From: Daun Johnson <[REDACTED]> on behalf of Planning.Responses
Sent: 04 April 2019 10:31
To: Sian Eggington
Subject: FW: Further Information Required on Your Ref: PP-07739676 Our Ref: M/28/19/HH
Attachments: 202 rev A Existing Plans and Sections.pdf; 204 rev B Proposed Plans and Sections.pdf; 102 rev A Site Block Plan.pdf; Flood map for planning.pdf
Categories: Green Category

From: PAUL REED [REDACTED]
Sent: 04 April 2019 10:21
To: Planning.Responses
Subject: Re: Further Information Required on Your Ref: PP-07739676 Our Ref: M/28/19/HH

Proposed Floor Plans and Sections

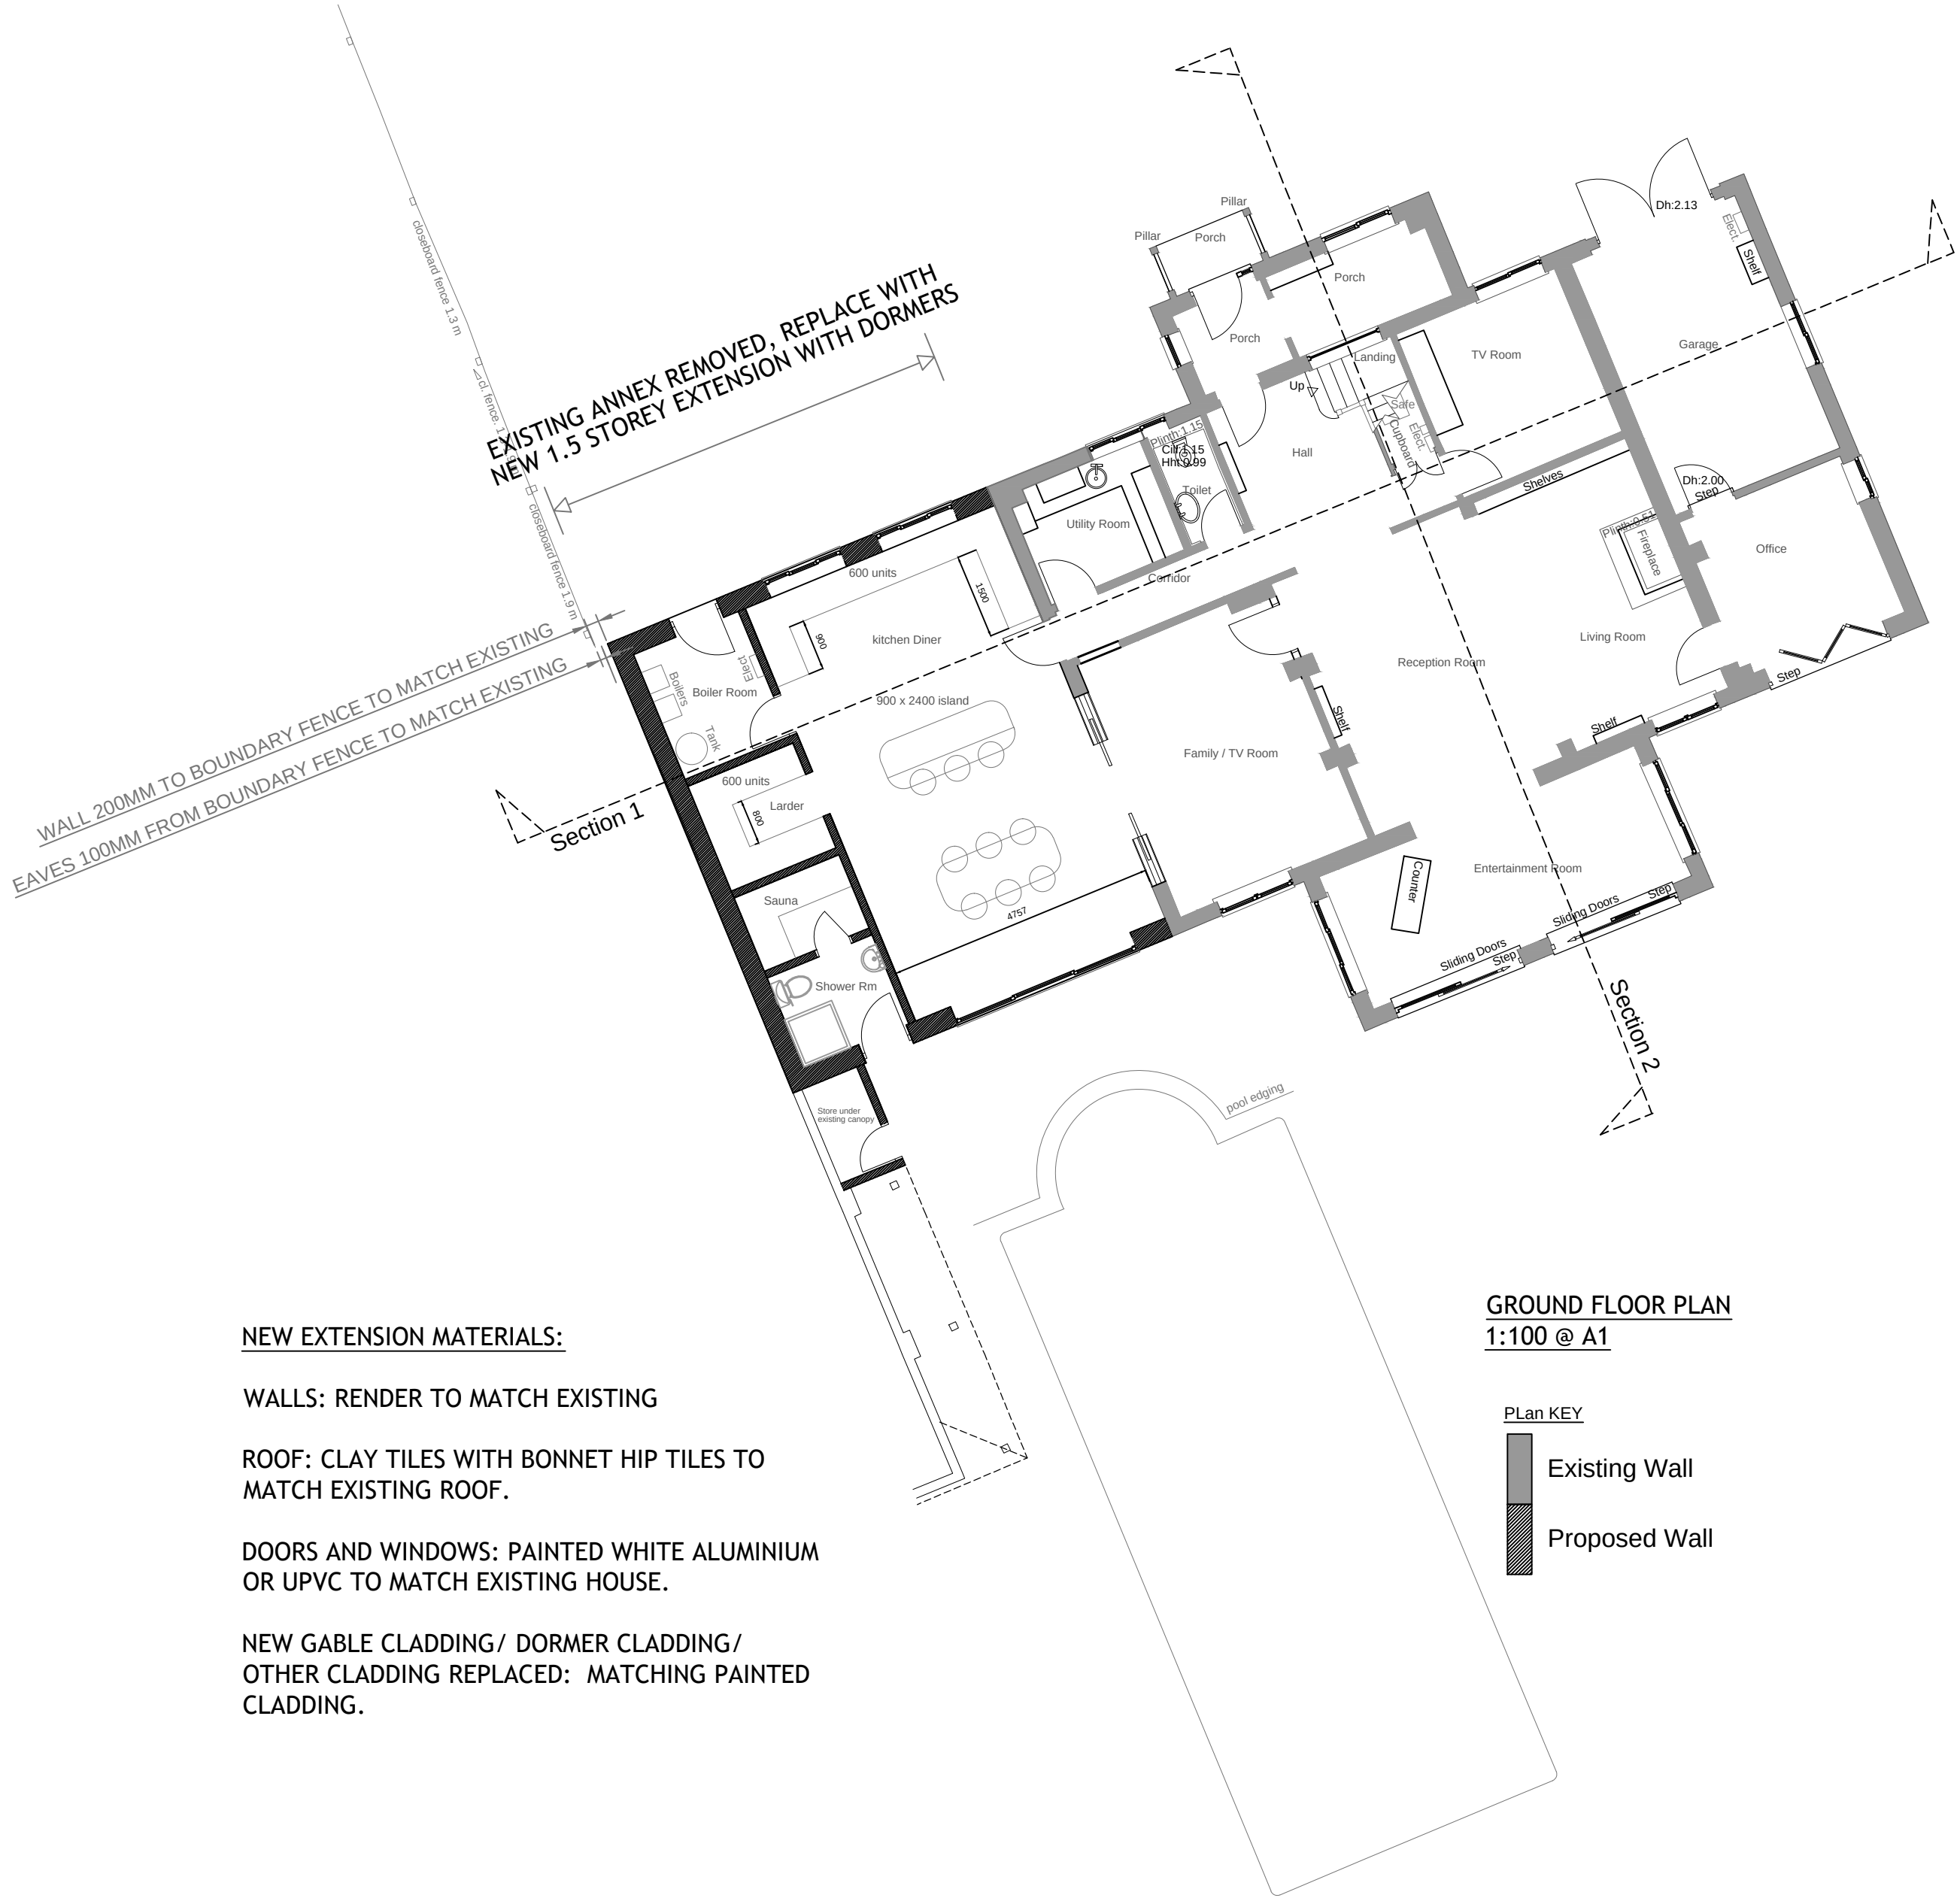
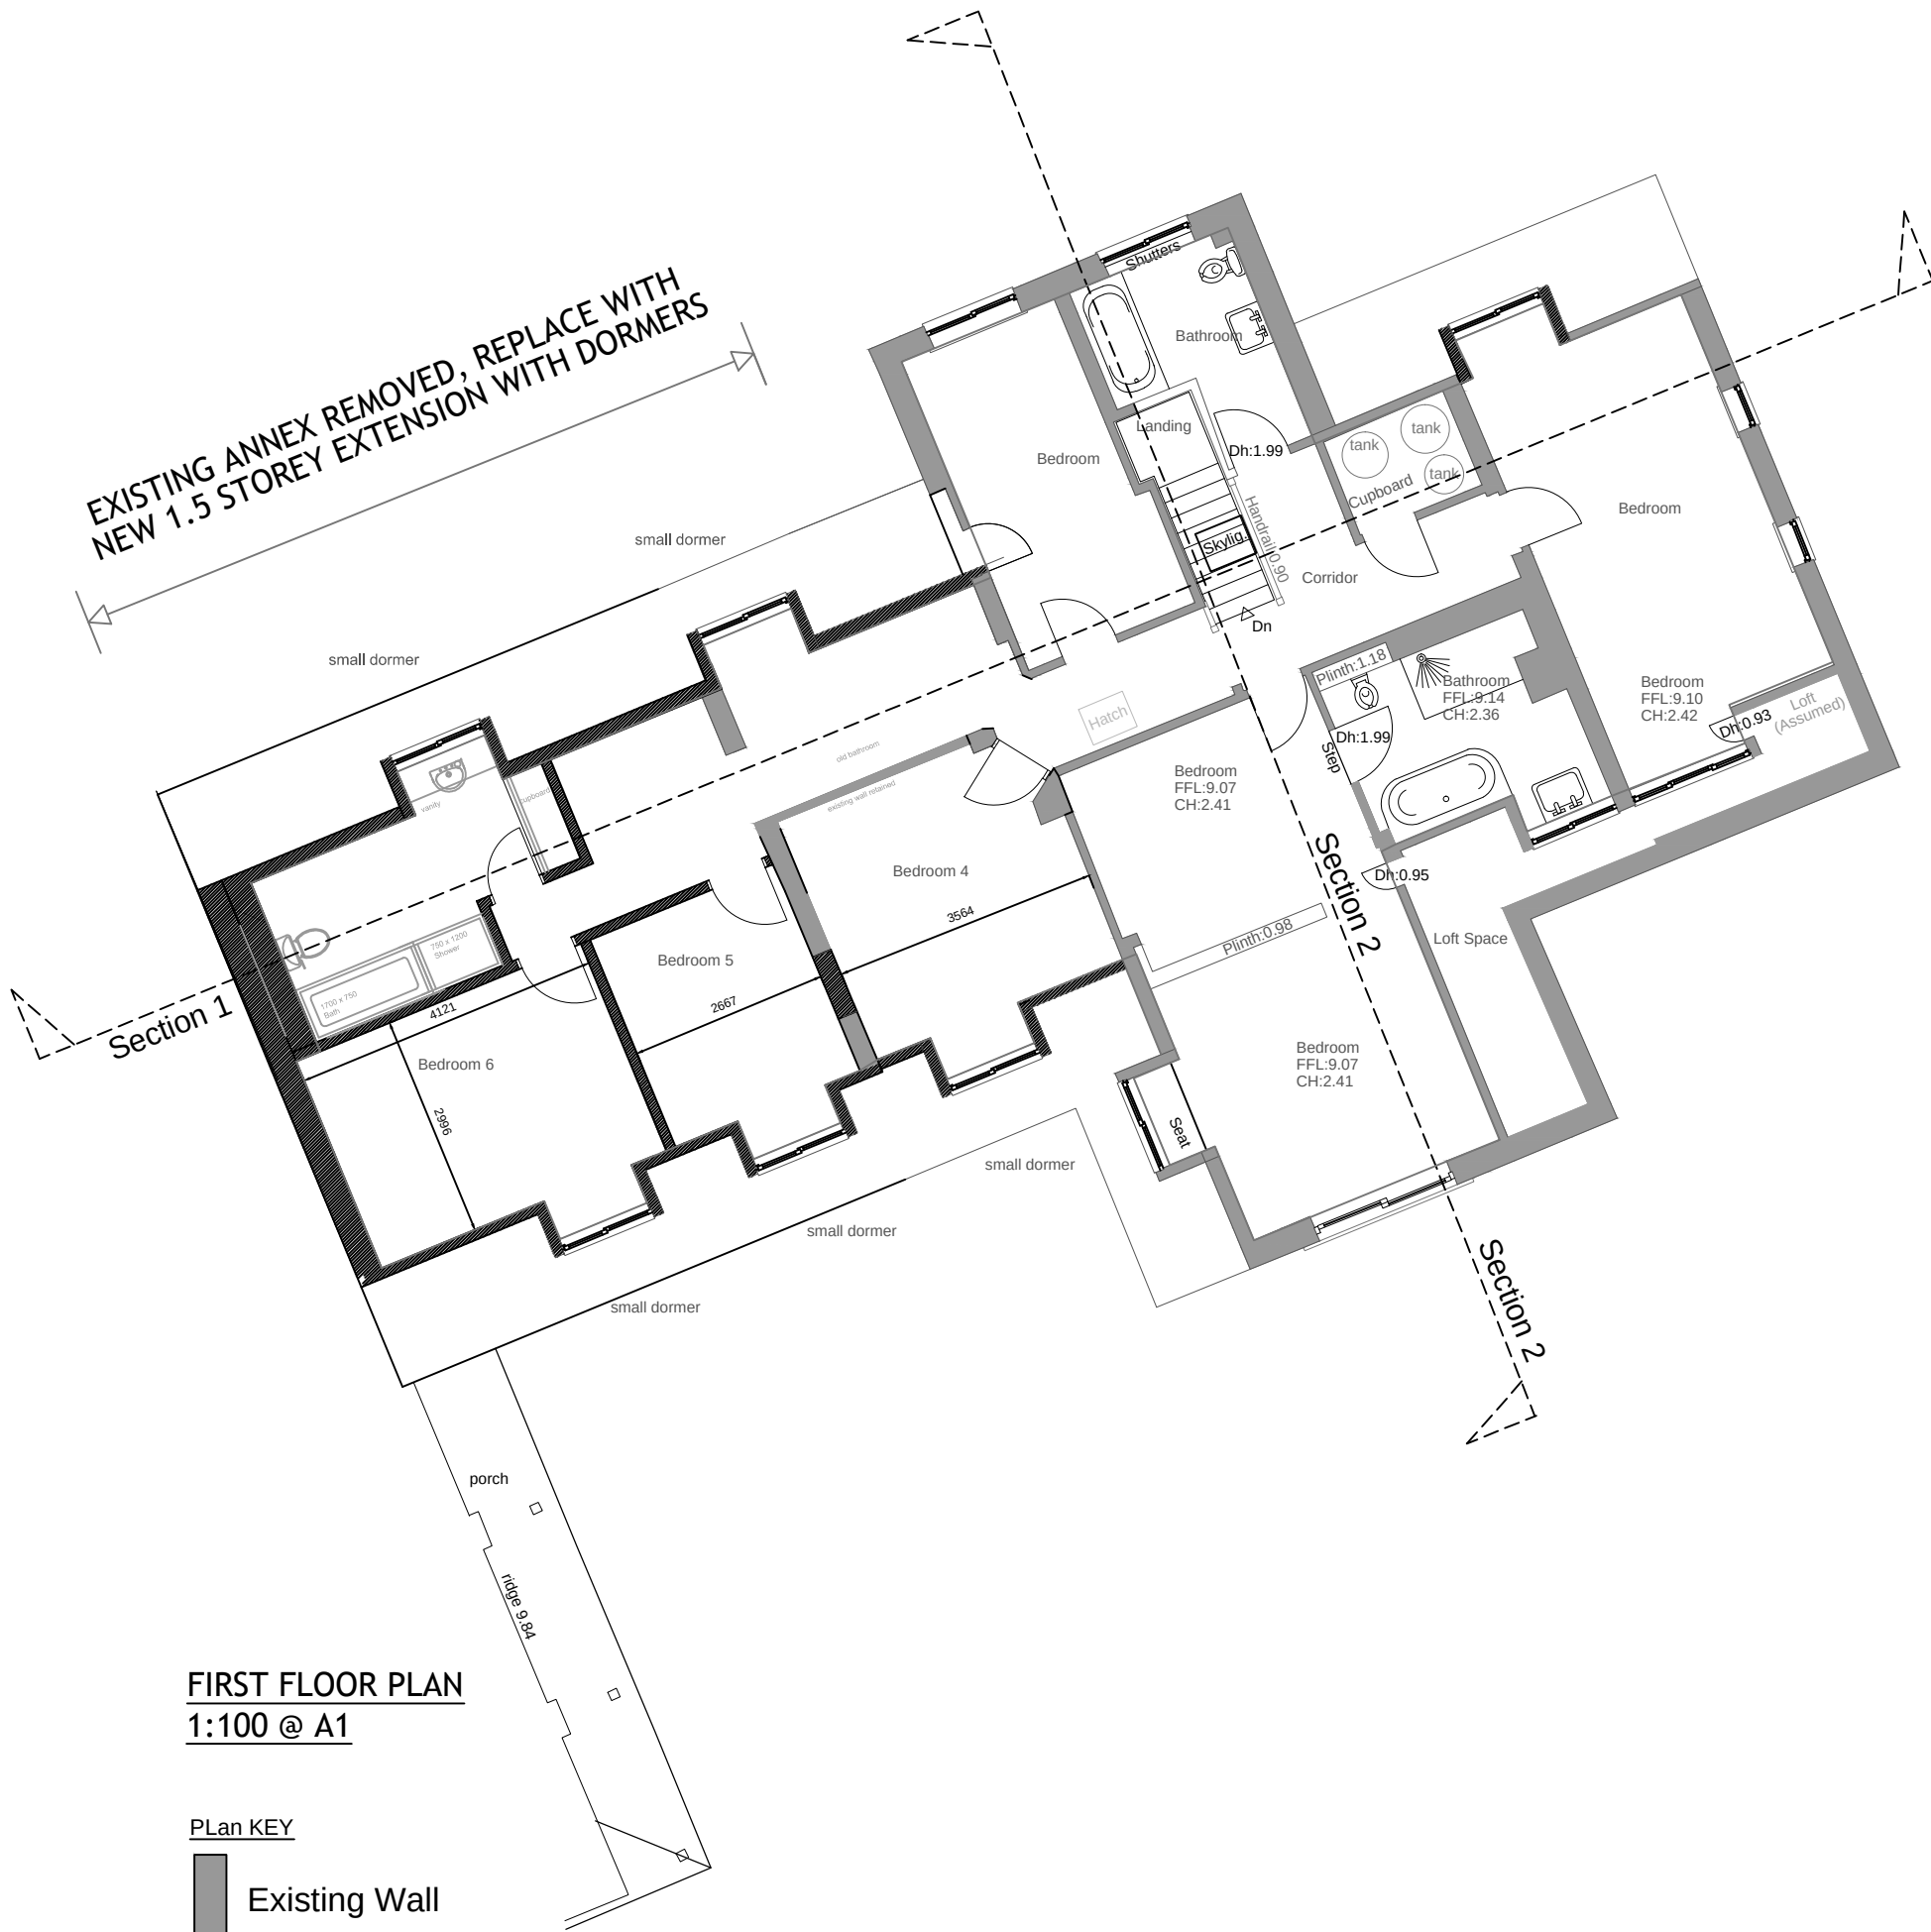
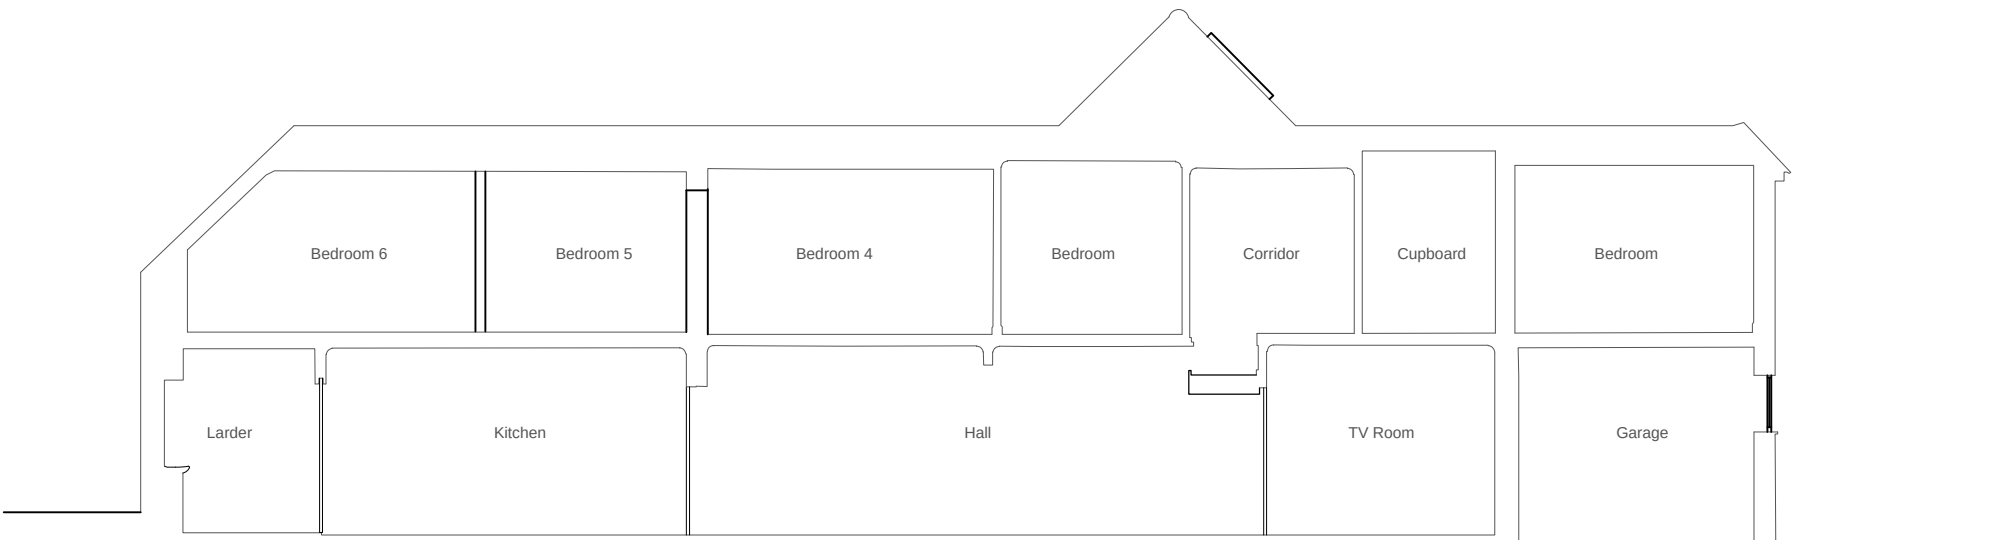
re 2) Block Plan dimensions, please find attached updated block plan showing dimensions, also existing and proposed plans updated showing this in more detail to the side boundary.
